MIRVAC

AUSTRALIAN TECHNOLOGY PARK
- BUILDING 1
- BUILDING 2
- COMMUNITY BUILDING
- PUBLIC DOMAIN

ACCESS REVIEW

10th December 2015

MIRVAC - AUSTRALIAN TECHNOLOGY PARK - BUILDING 1

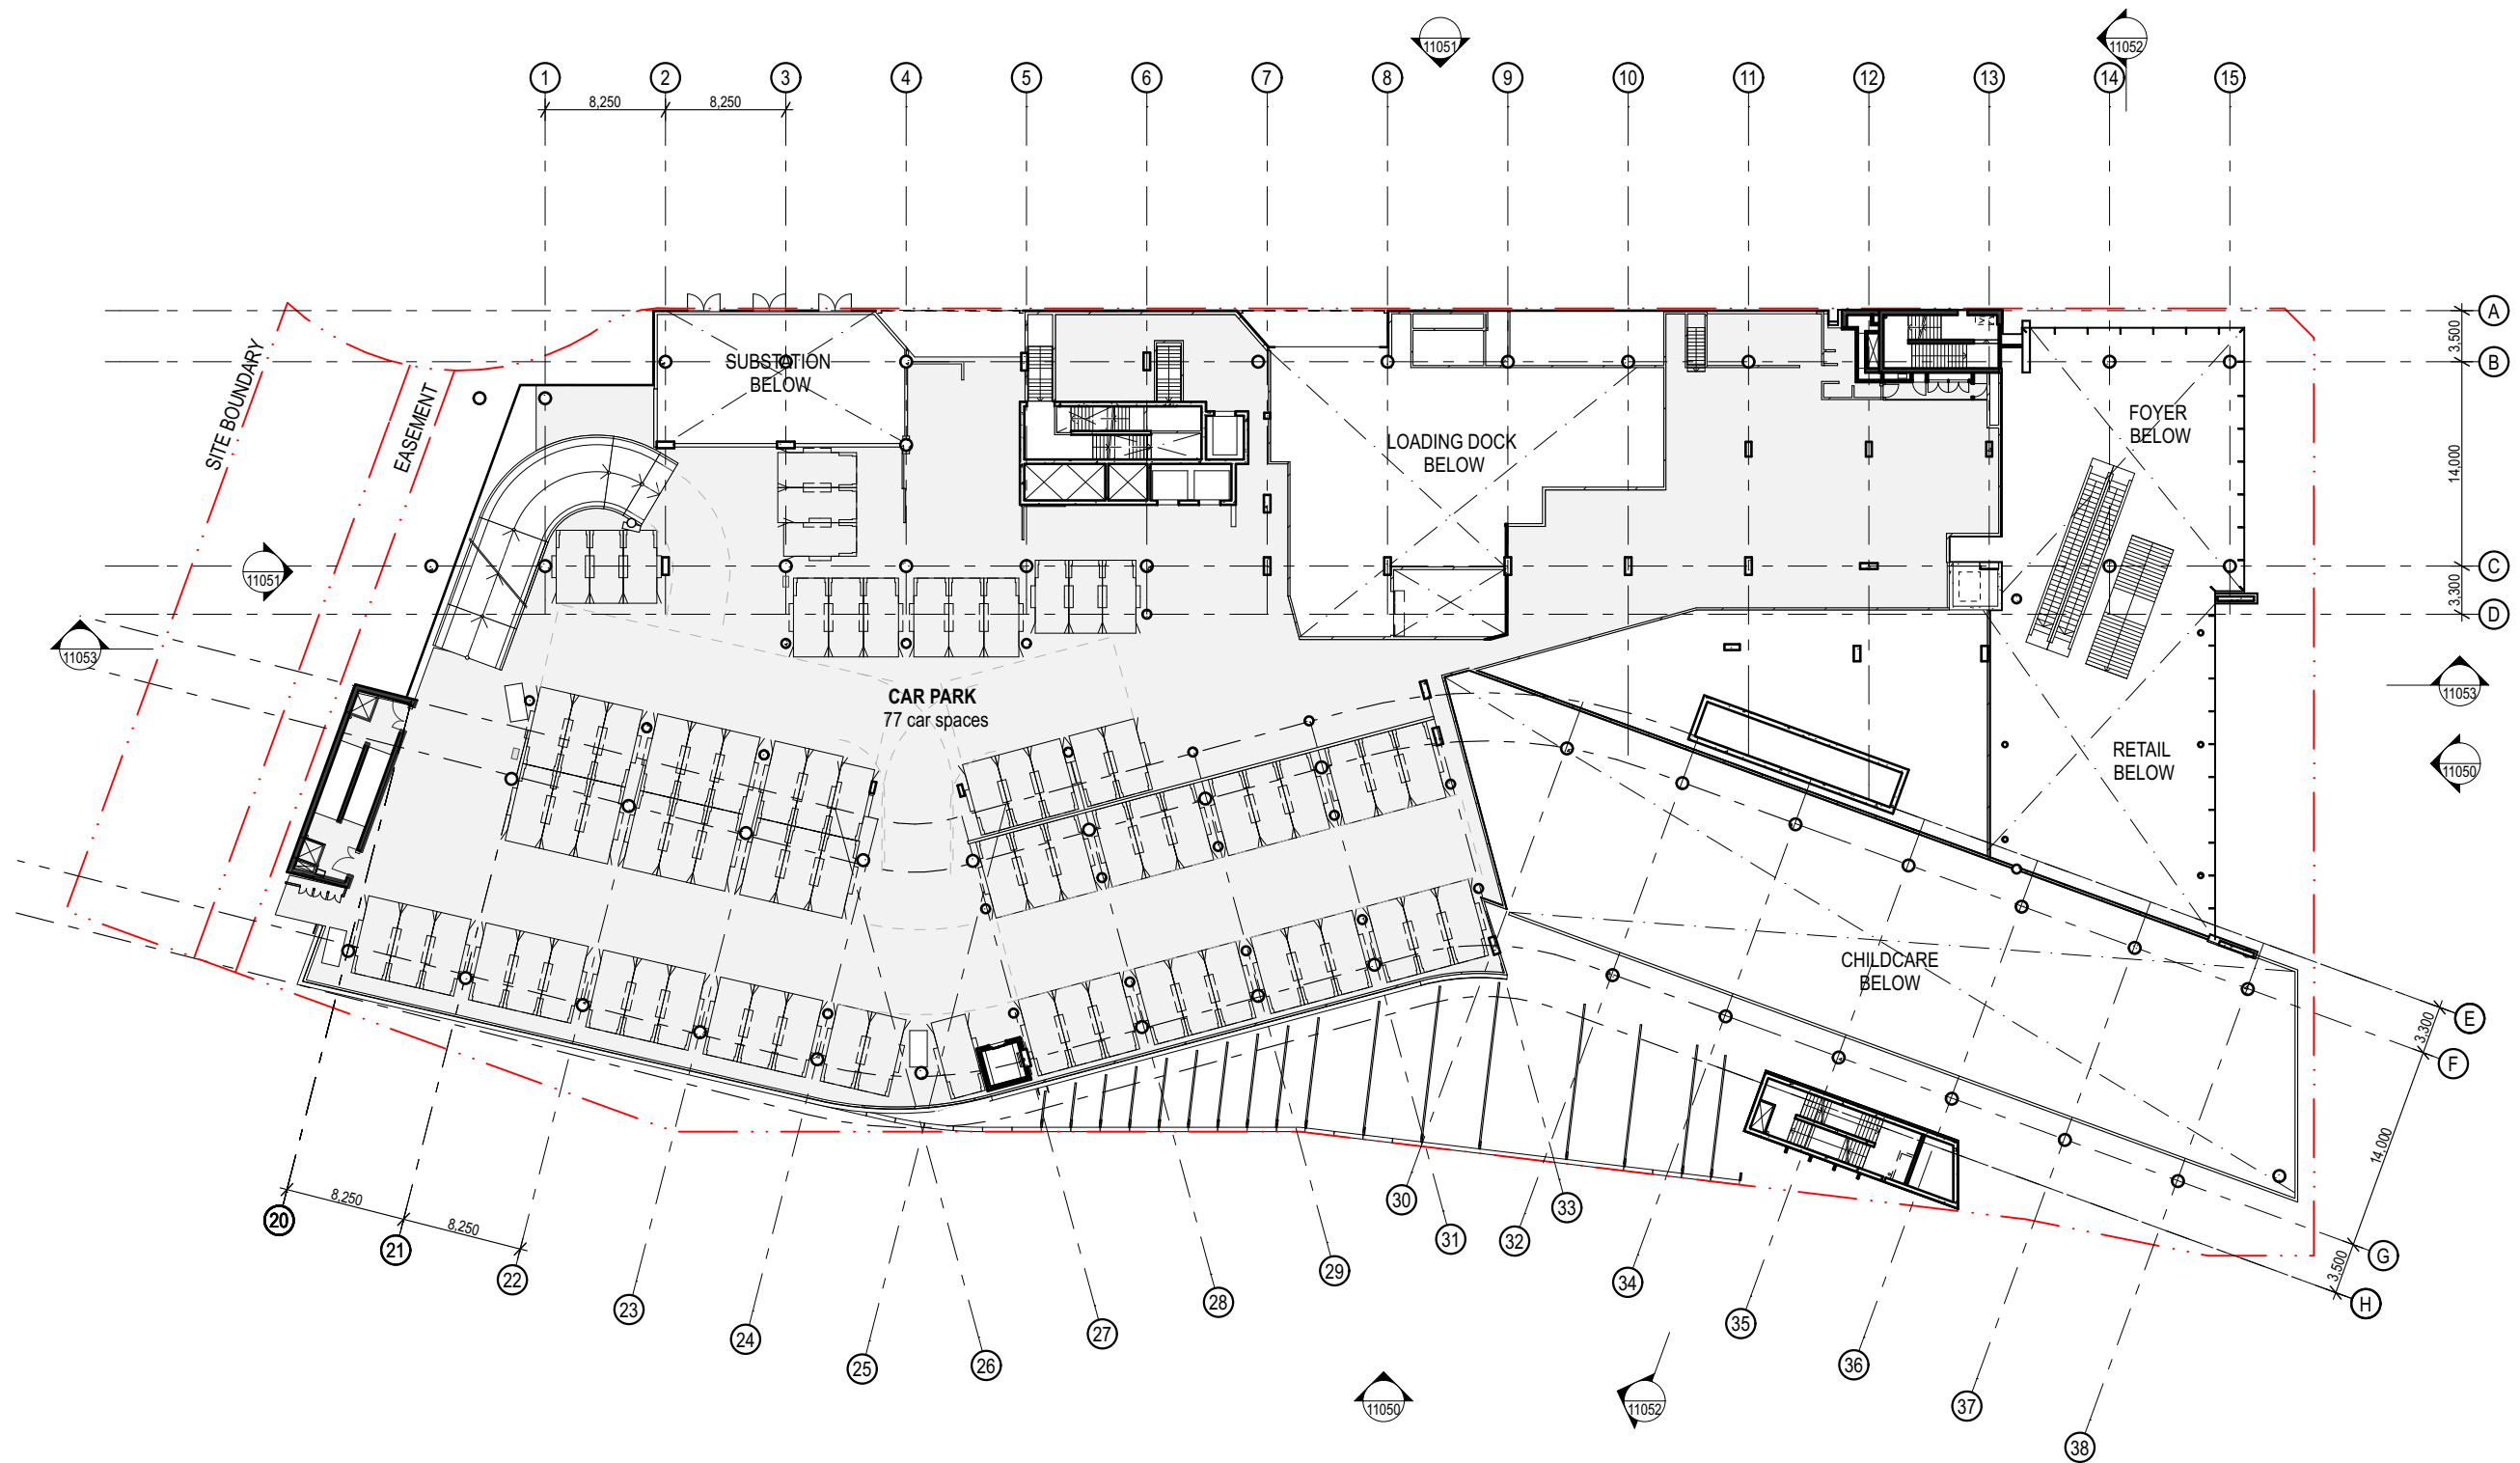
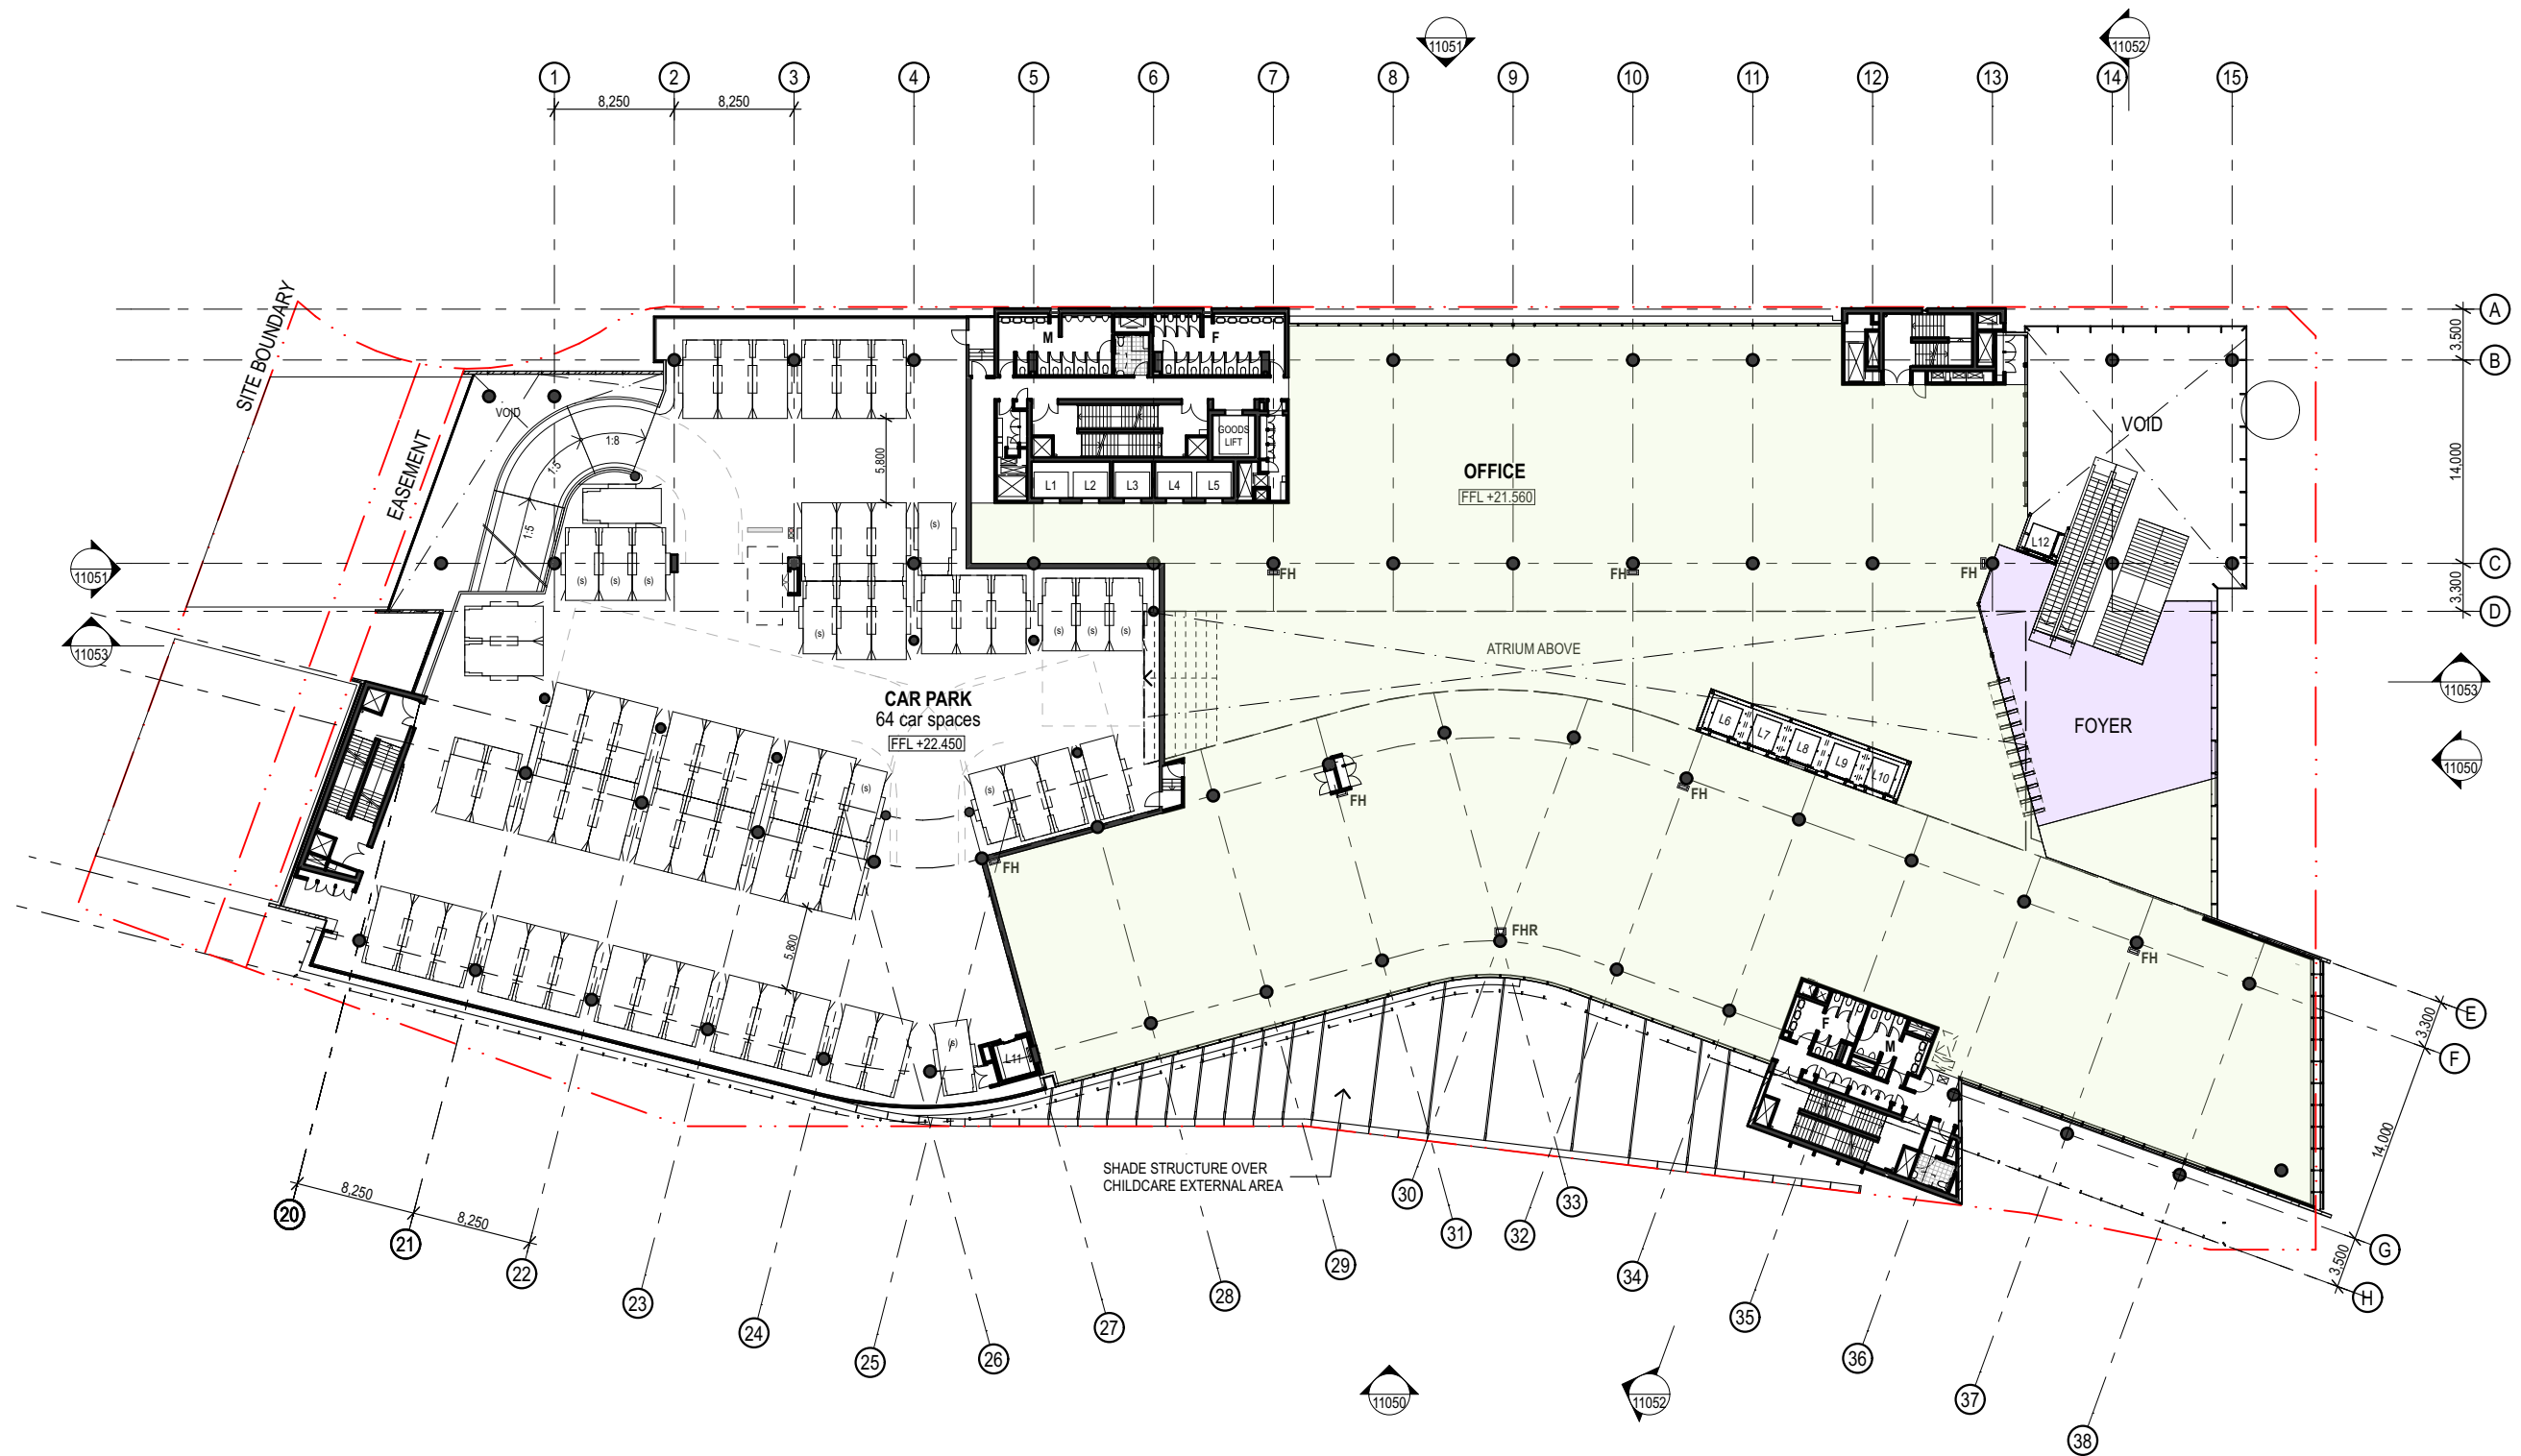
However, the accessible path of travel from the accessible car bays located on the floor ground floor level to the entry point of the End of Trip Facilities will need to be provided with turning circles, 1540mm in width for a minimum length of 2070mm, for compliance under AS1428.1:2009. This is due to the current corridor having a length greater than 20m and a width of only 1500mm.

However, the basin located within the right hand transfer accessible toilet currently encroaches within the circulation space of the shower. This is due to the structural column located to the corner of the room.

Also, drawings indicate there to be a total of 17 right hand transfer pans and only 8 left hand transfer pans. As per the DDA Premises Standards, an even amount of left and right handed pans is required to fulfil compliance.

Car parking has been provided to the lower ground floor level, mezzanine level and upper ground floor level of the building, with a total of 217 car spaces. A total of 5 accessible parking bays have been provided to the lower ground floor level. The number of accessible parking bays satisfies the requirements of the DDA Premises Standards table D3.5.

- (i) Ensure flooring systems used comply with BCA and HB198/AS4586.
- (ii) Turning circle of no less than 1540mm wide x 2070mm length to be provided to the accessible path of travel leading from the accessible car bays to the entry point of the End of Trip Facilities on the lower ground floor level.

- (i) Ensure a clear circulation space about the shower recess to the ground floor accessible toilet of 1600mm x 2350mm, compliant with AS1428.1:2009.
- (ii) The public accessible toilets throughout shall have suitable pan locations that allow a mixture of left and right transfer pans, compliant with AS1428.1:2009 and the DDA Premises Standards.
- (iii) Ensure all bathroom fixtures comply with AS1428.1:2009.

- (i) Ensure the accessible car bay has a vertical clearance of 2.2m whilst travelling to the accessible car bay and 2.5m within the accessible car bay, compliant with AS2890.6.
- (ii) Ensure there is a safe and accessible path of travel to the lifts from the car bays. Consideration shall be given as to relocate the accessible parking bay closer to the lift lobby.
